**MRGCD Engineering/Mapping Plat Reviews**

**Project No:** DRB2021-4985

**Plat Type:** Sketch Plat

PLAT OF TRACT H4A1A, BLOCK 2 STRONGHURST ADDITION

Plat of
Tract H-4A-1-A, Block 2
Stronghurst Addition
 Town of Albuquerque Grant, Projected
 Section 9, Township 10 North, Range 3 East, N.M.P.M.
 Albuquerque, Bernalillo County, New Mexico
 January 2021

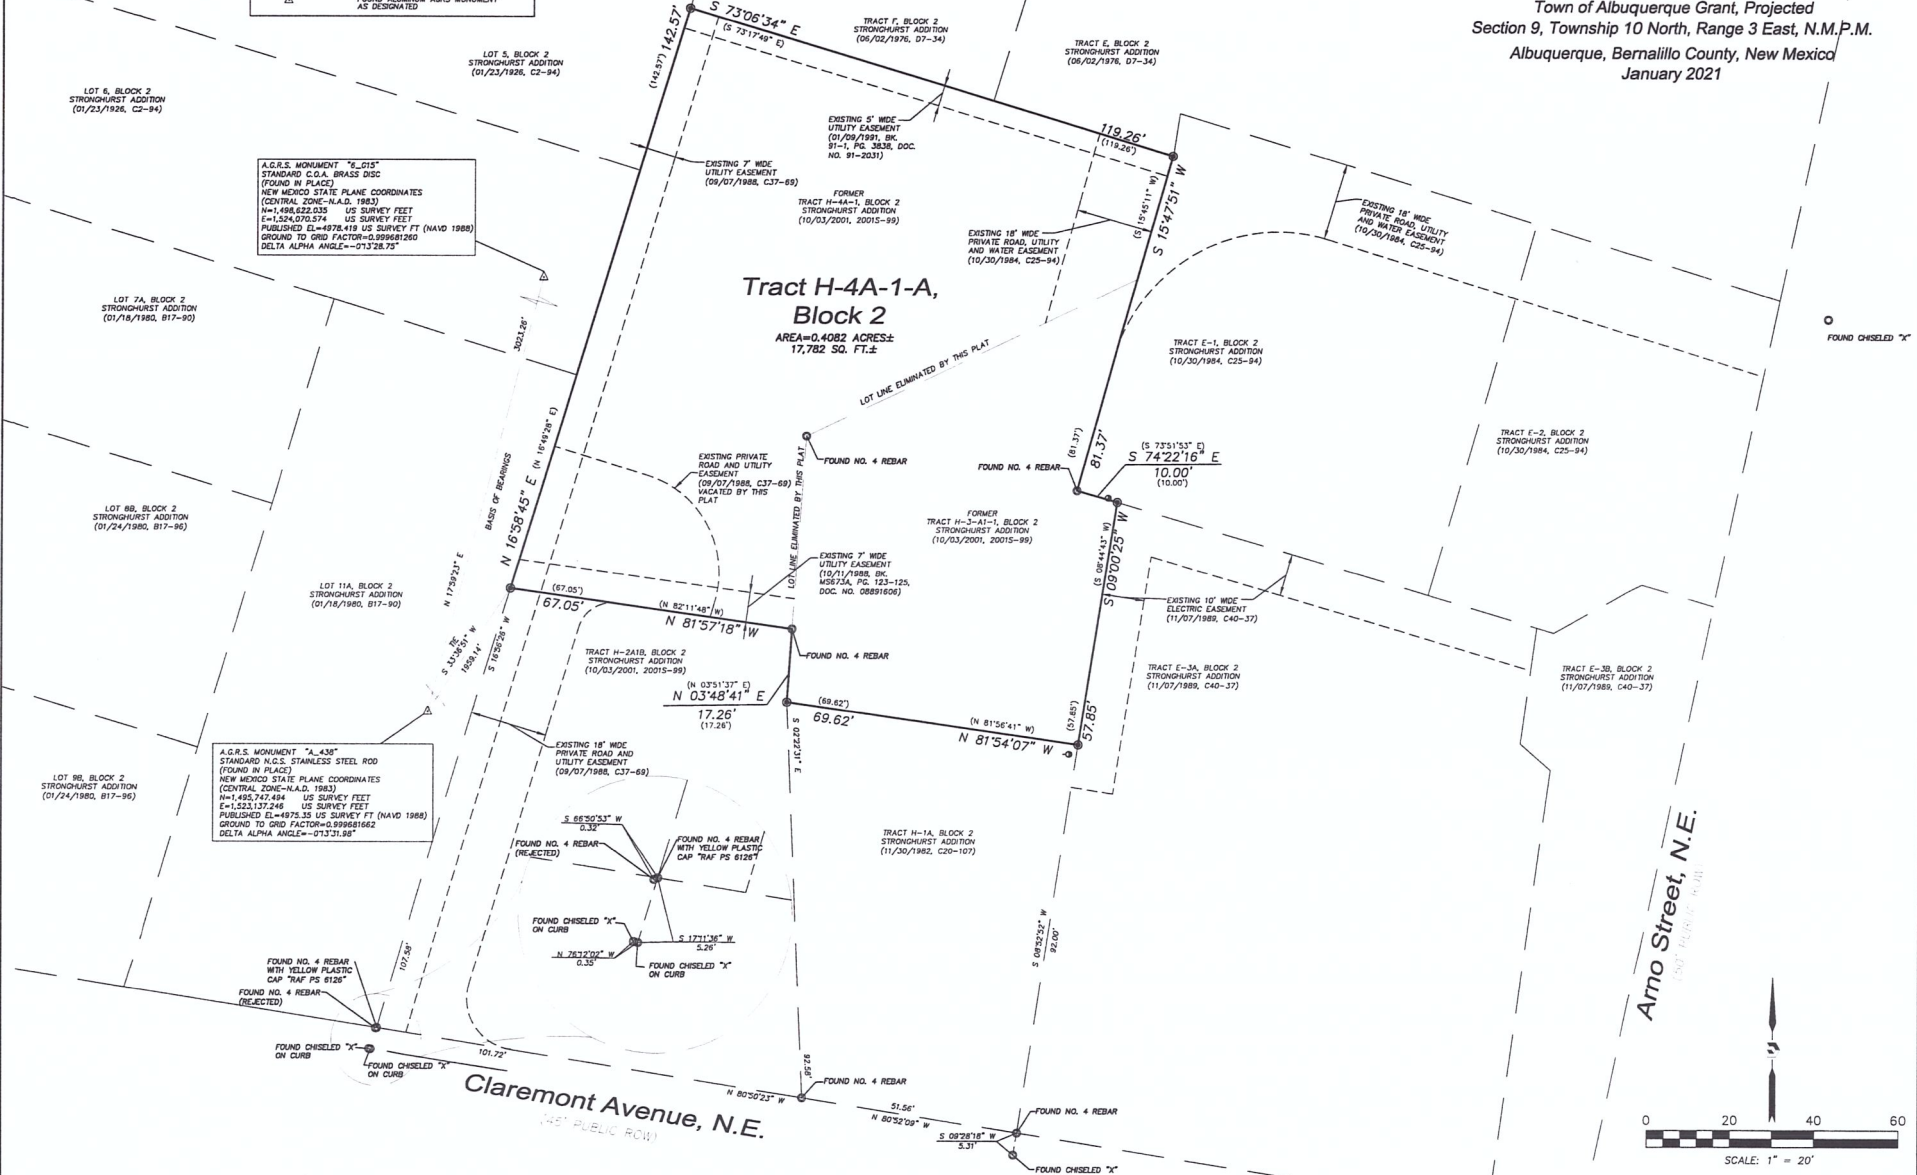
1. Please add MRGCD signature line with other signatories on page 1.
2. Please add MRGCD Approval Note to page 1 of plat.
3. Final Plat Approval Signature required by the MRGCD.
